Our Ref: PR107832

Date: 8 May 2013

RE: SSD-4949-2011: 157-163 Cleveland St, Redfern – S96(1A) Application Reconfigure Accommodation Units and Overall Reduction in Number of Occupants

Student Housing
157 - 163 Cleveland St Redfern
Key Plan - Level 02

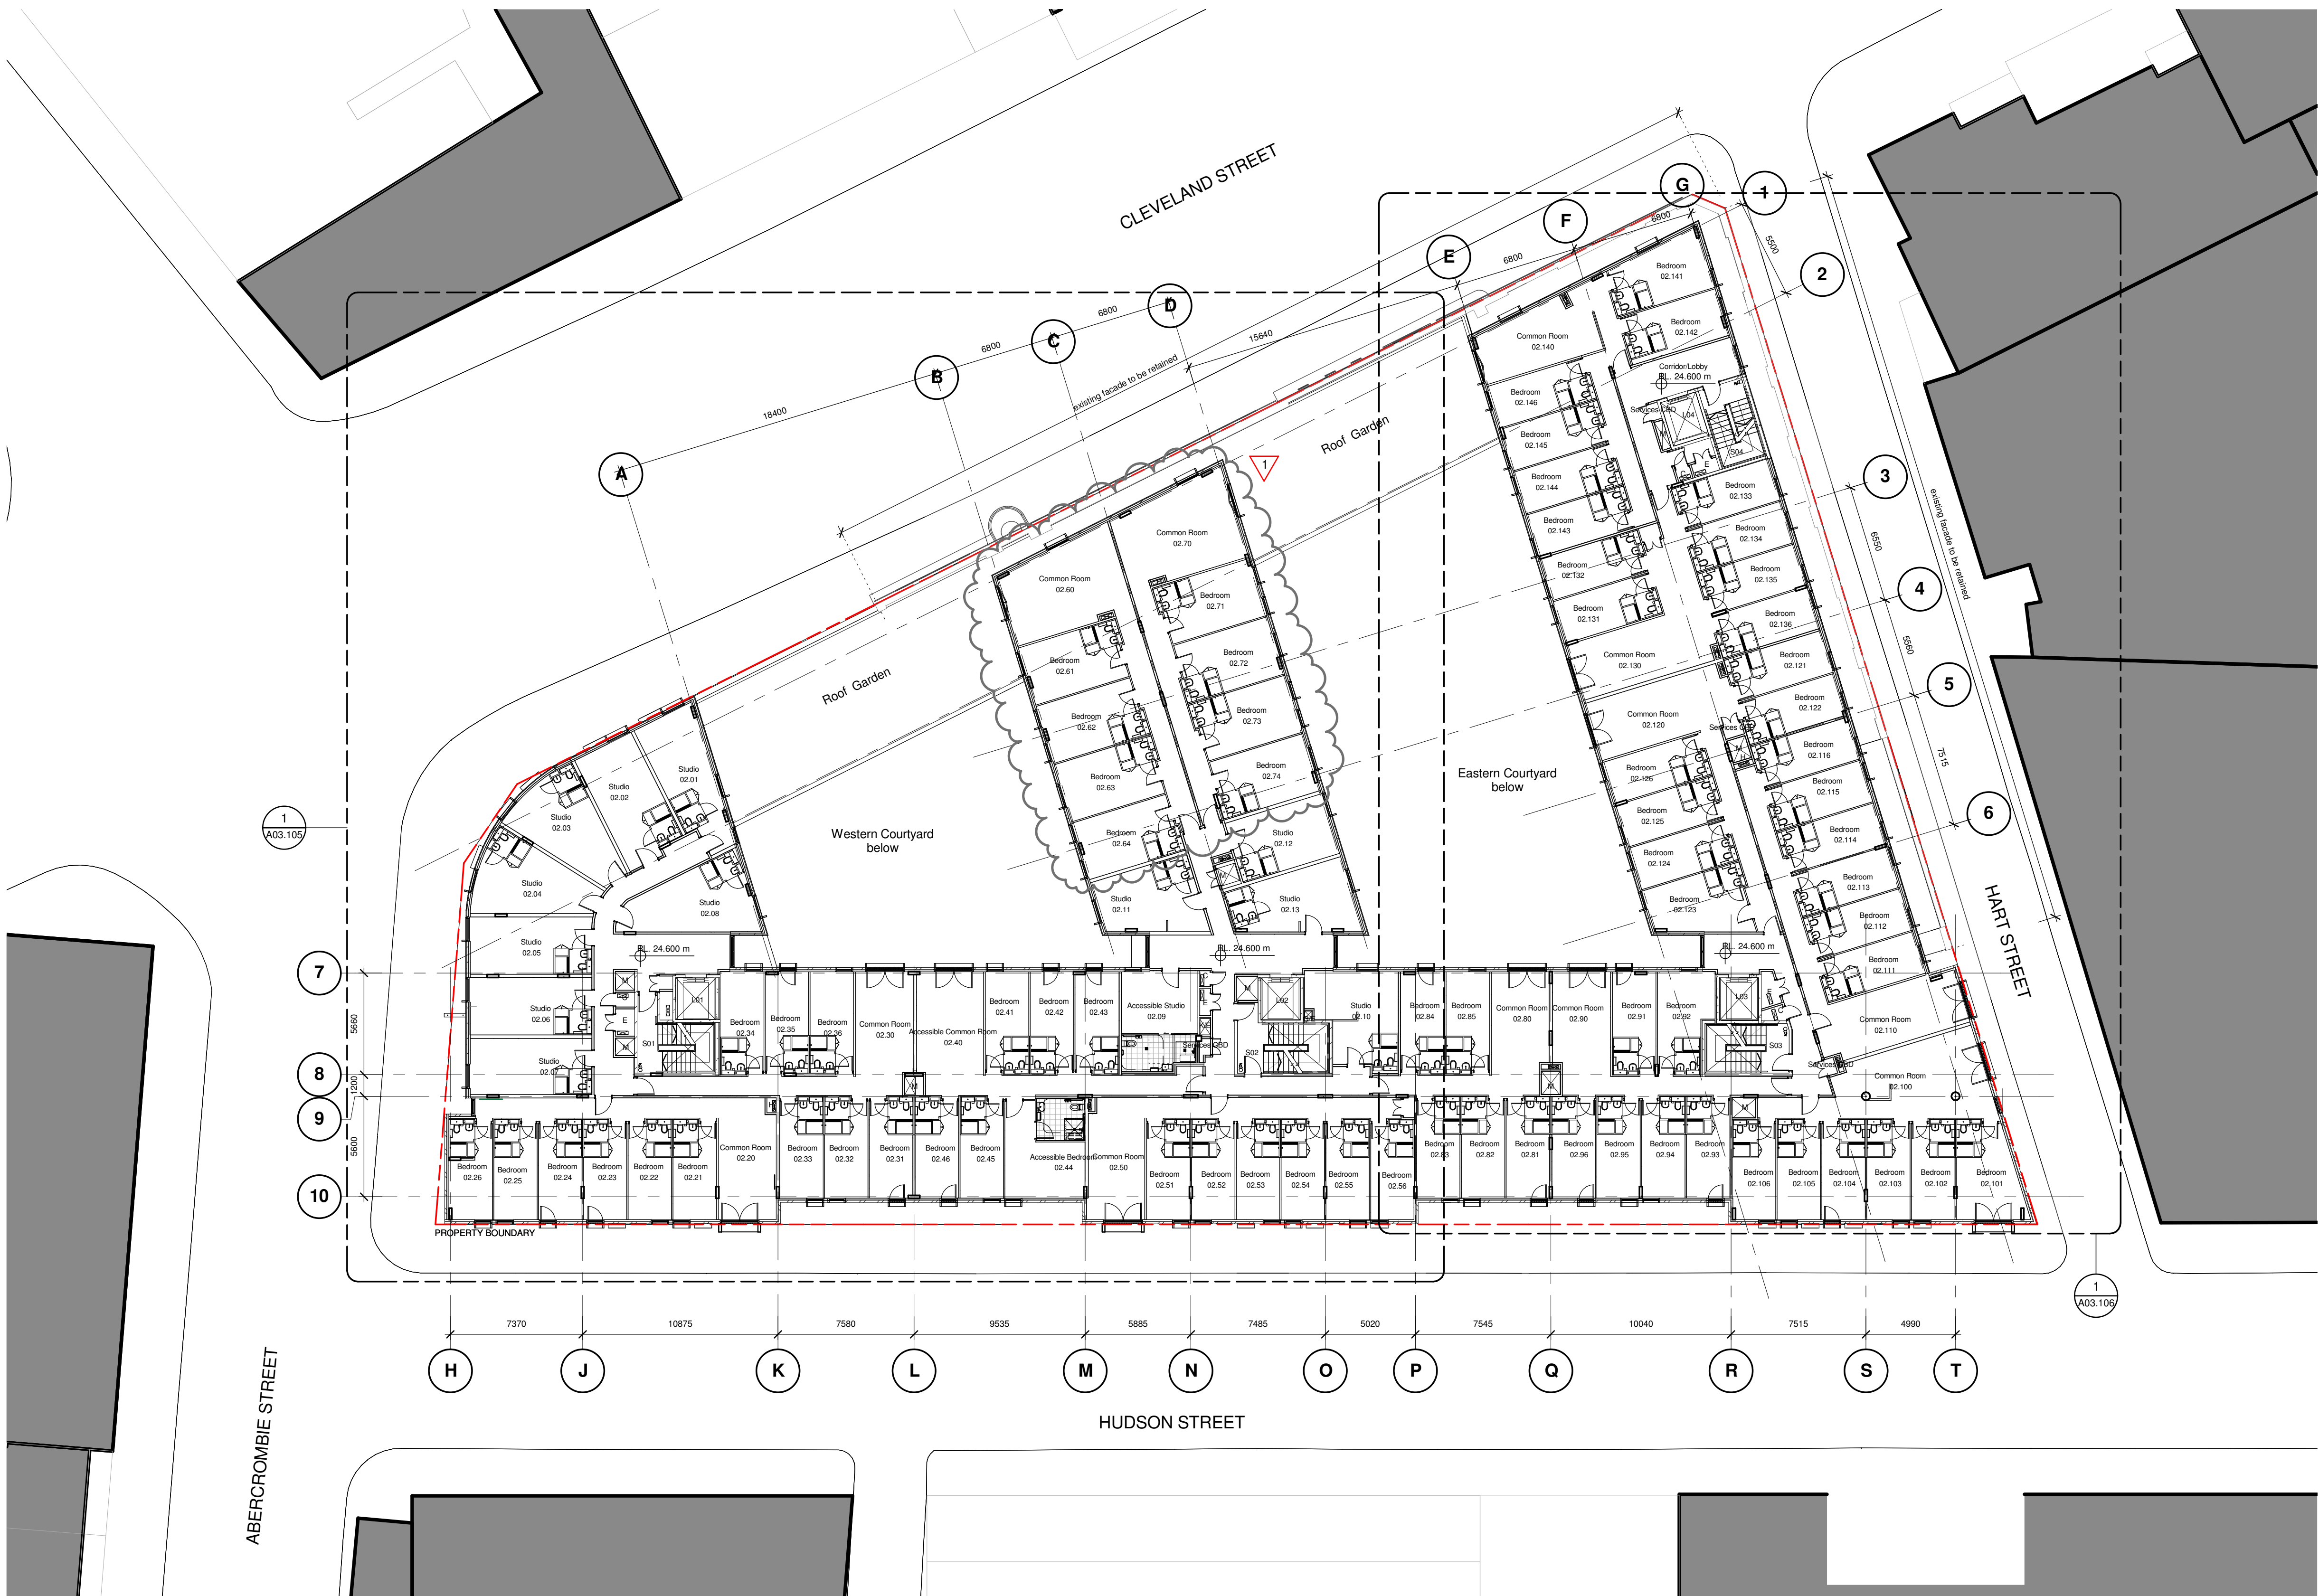
This application seeks reduce the overall number of students in the building to 445 and modify the internal layout of the accommodation in the middle wing.

Central Wing Level	Original Proposal	Modification
1	11 single rooms 3 studios 2 common rooms	5 single rooms 4 twin rooms 3 studios 2 common rooms
2	12 single rooms 3 studios 2 common rooms	8 twin rooms 3 studios 2 common rooms
3	12 single rooms 3 studios 2 common rooms	8 twin rooms 3 studios 2 common rooms
4	12 single rooms 3 studios 2 common rooms	8 twin rooms 3 studios 2 common rooms

Some other modifications to access and removal of hallway doors are also proposed to increase the functionality of the accommodation layout.

Student Housing
157 - 163 Cleveland St Redfern
Inner Courtyard Elevations

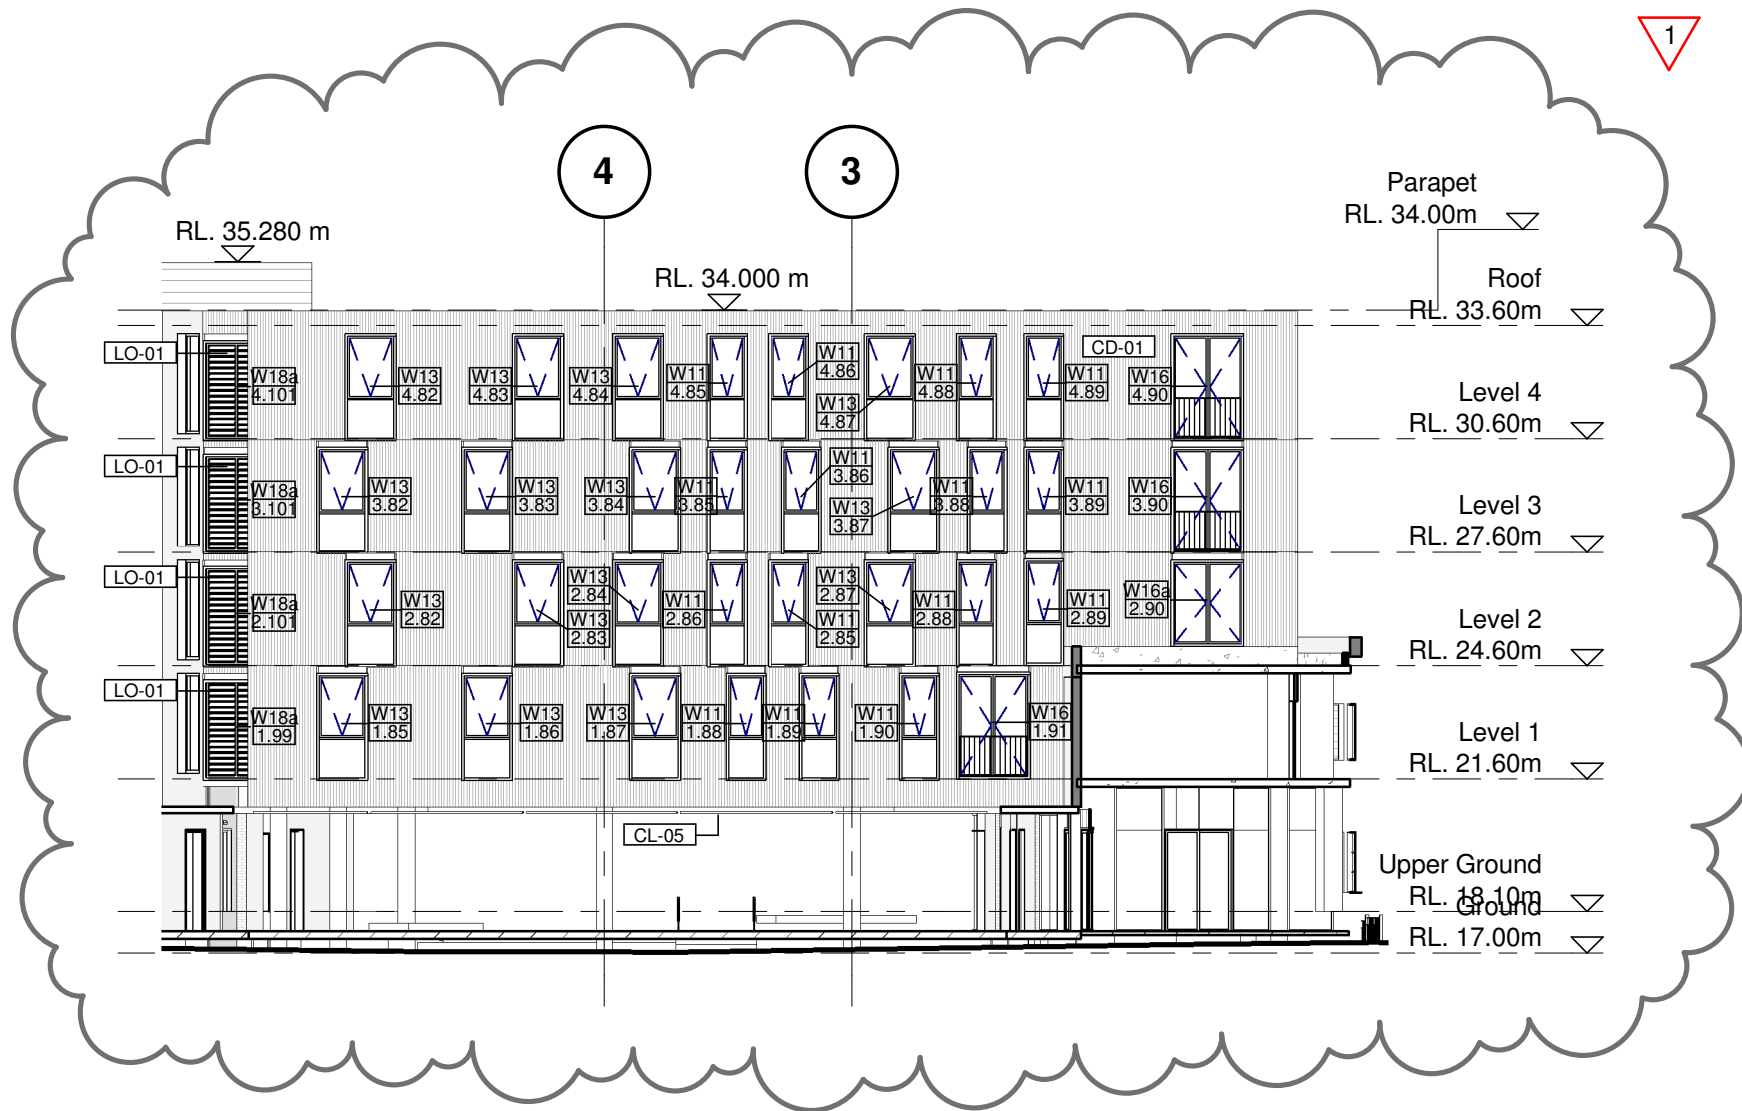
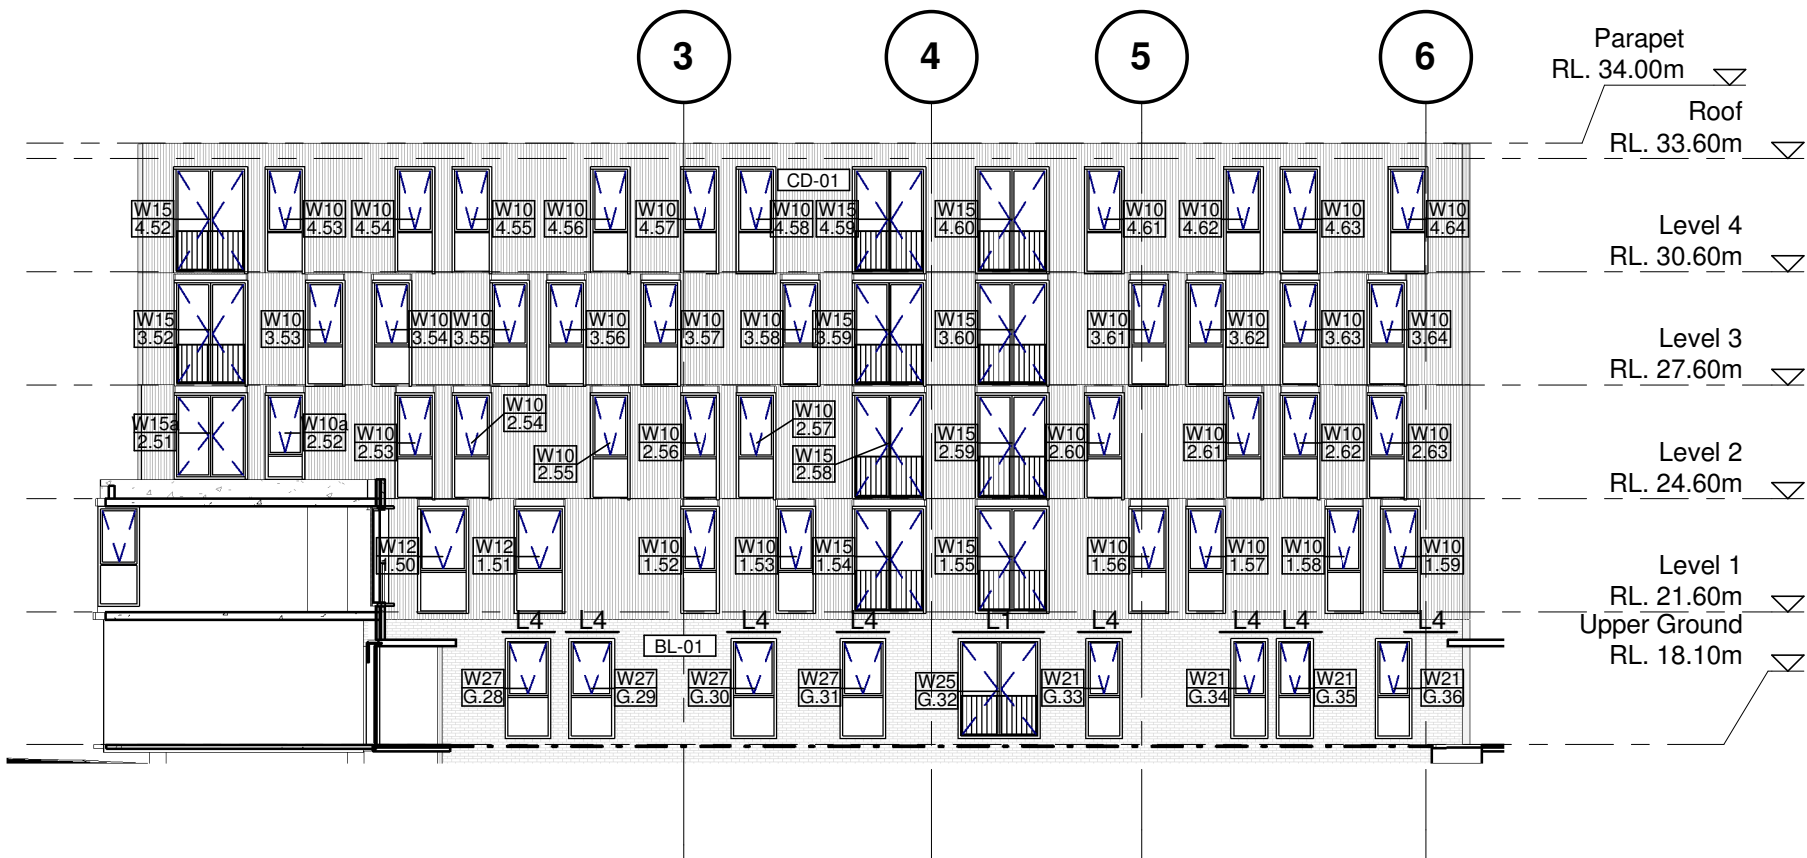
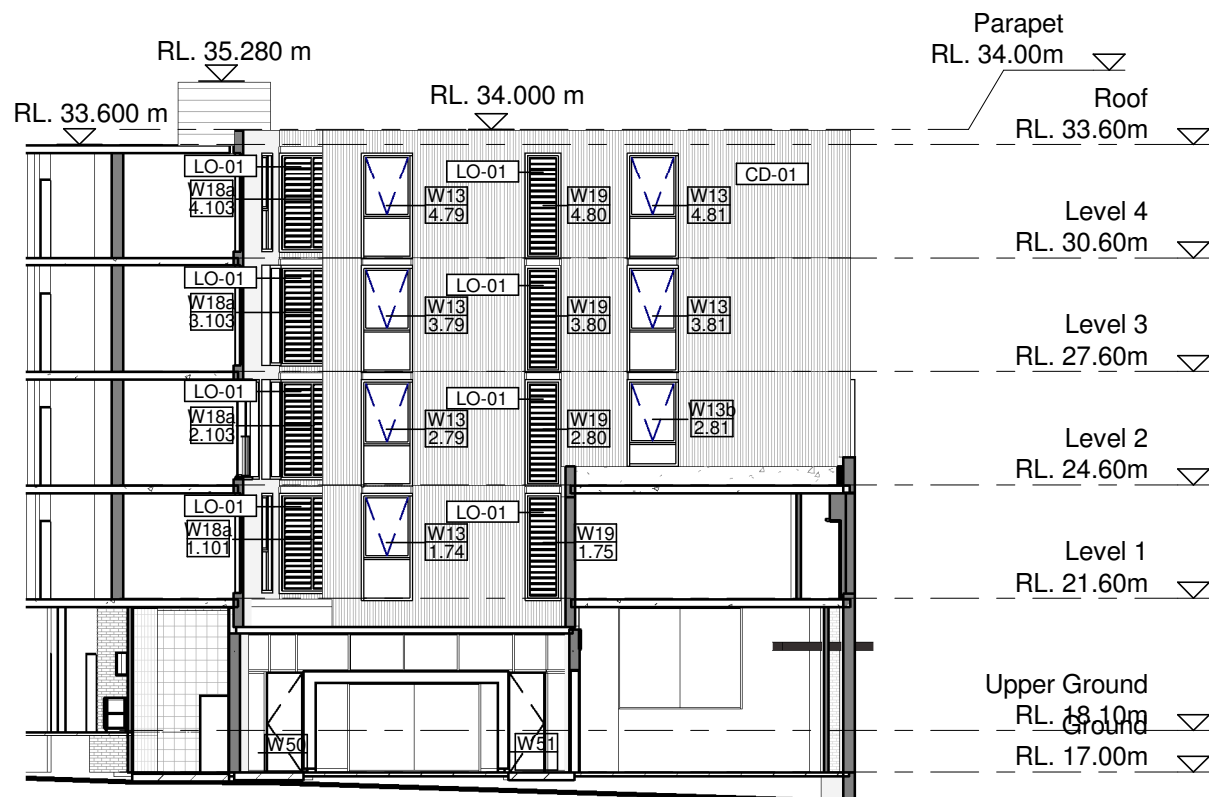
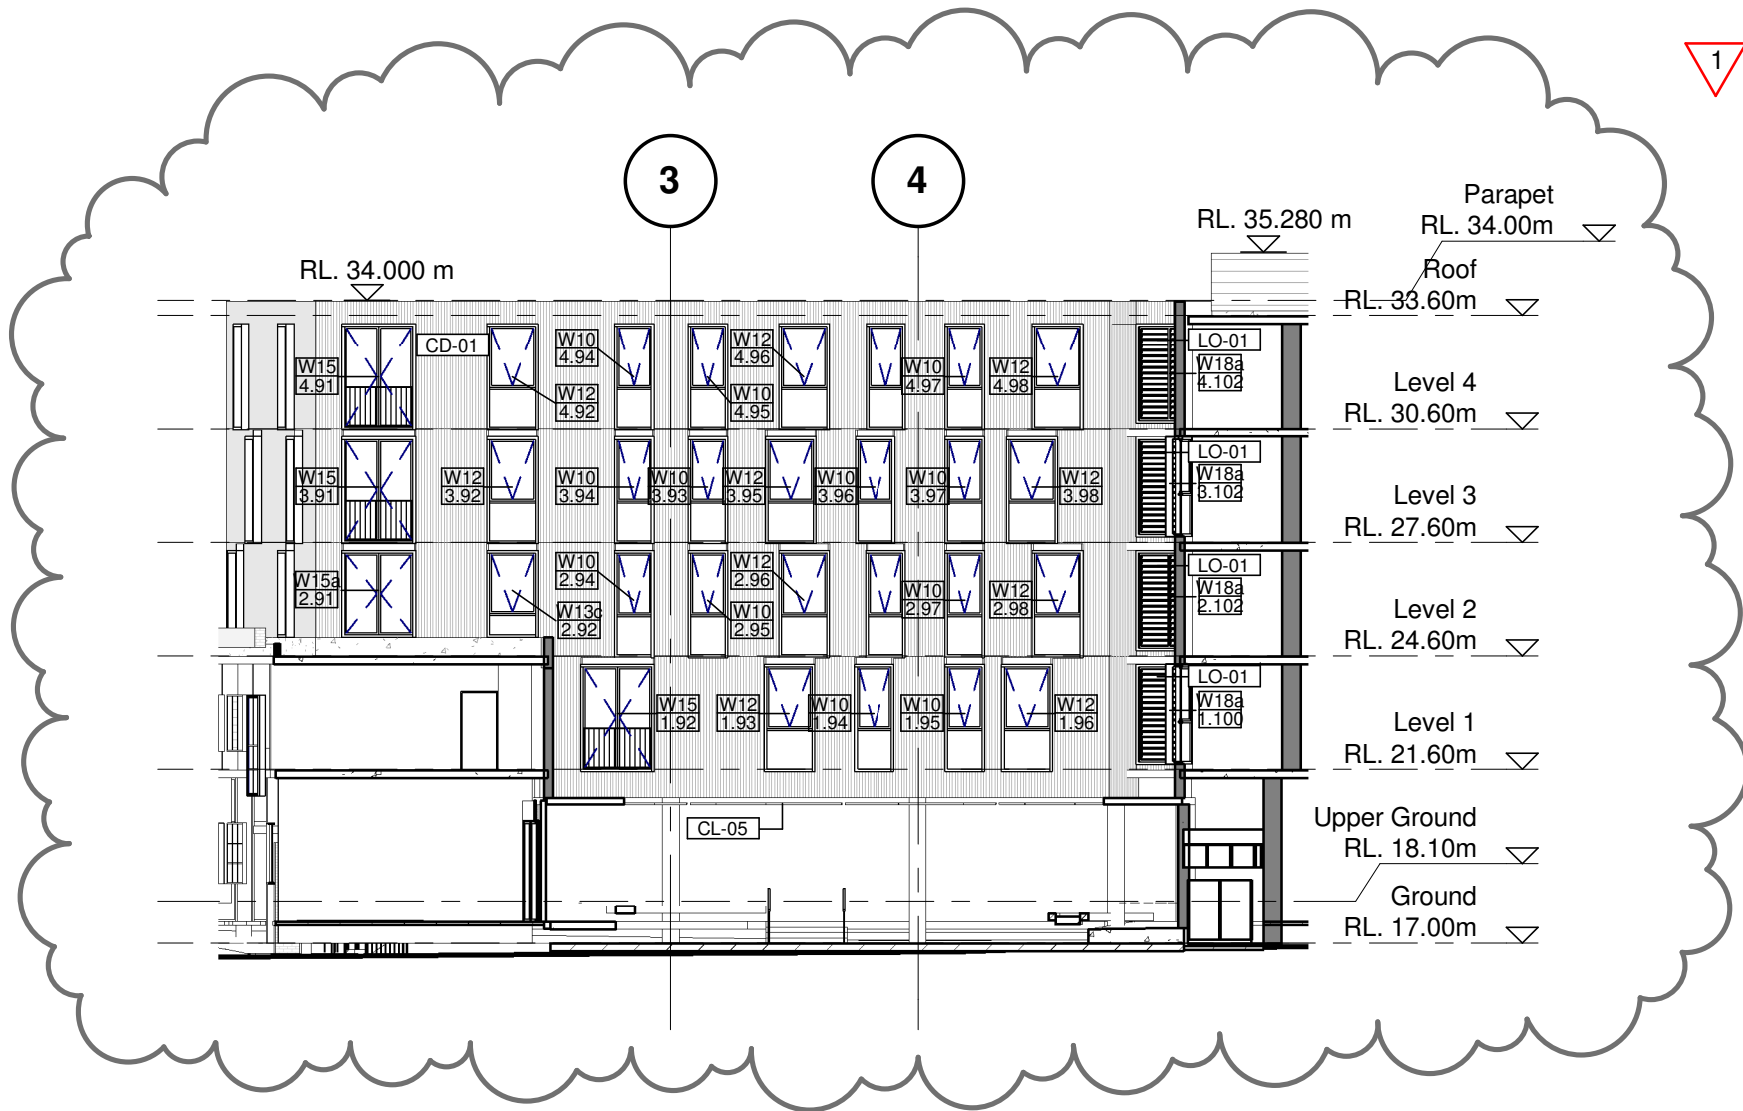
Window locations have changed however the majority are internal facing and will not impact the streetscape. Those that face the street conform the random rhythm of placement previously designed. The numbers of windows remain the same.

Windows and access to natural light is maintained to all rooms. The majority of windows to this central wing face internal to the inner courtyard areas and have no impact on the streetscape. Only two windows on each level face the Cleveland Street frontage. All windows and Juliet balconies proposed will maintain the design rhythm of the existing proposal.
